Fox Run Substation Construction of a New Substation including Grading, Drainage, and Surface Improvements El Paso County, Colorado

Grading and Erosion Control Plans (standalone)

Please add PCD File # PPR-22-44 all sheets 1-19

**FOX RUN SUBSTATION
COVER SHEET**

S9088-A-01-003

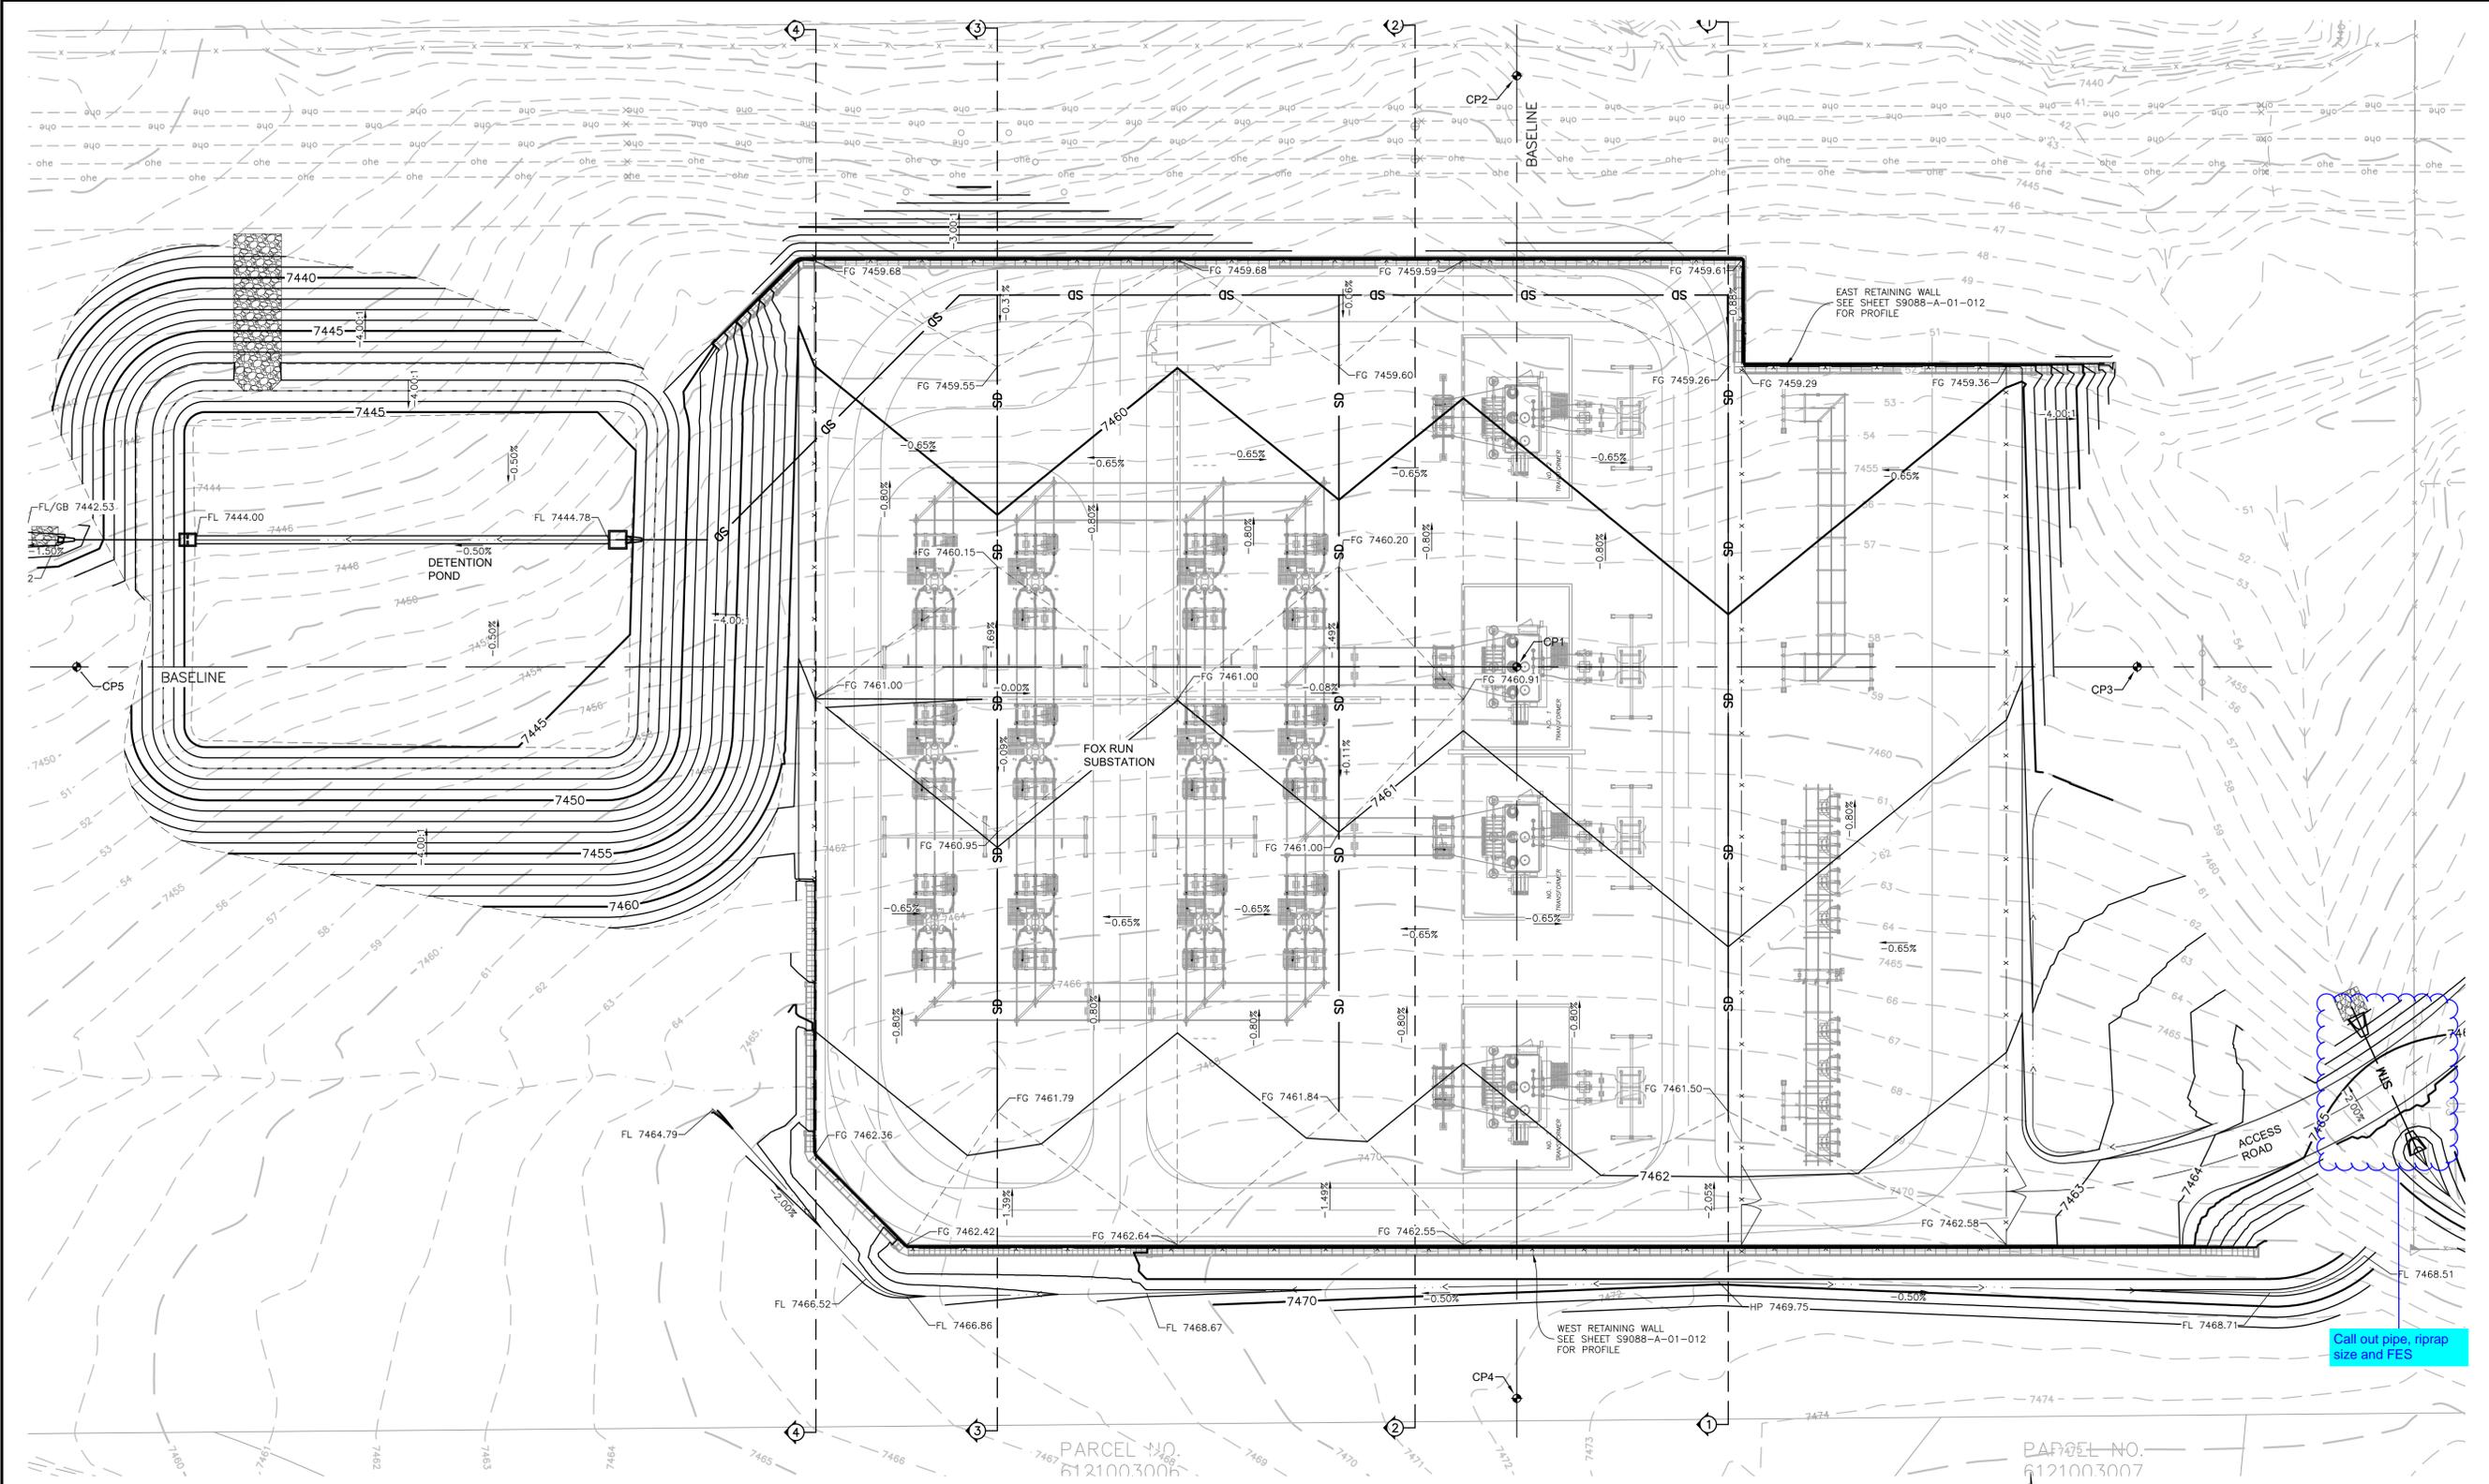
Show 15ft maintenance easement around impoundment structure with ramp access down into structure
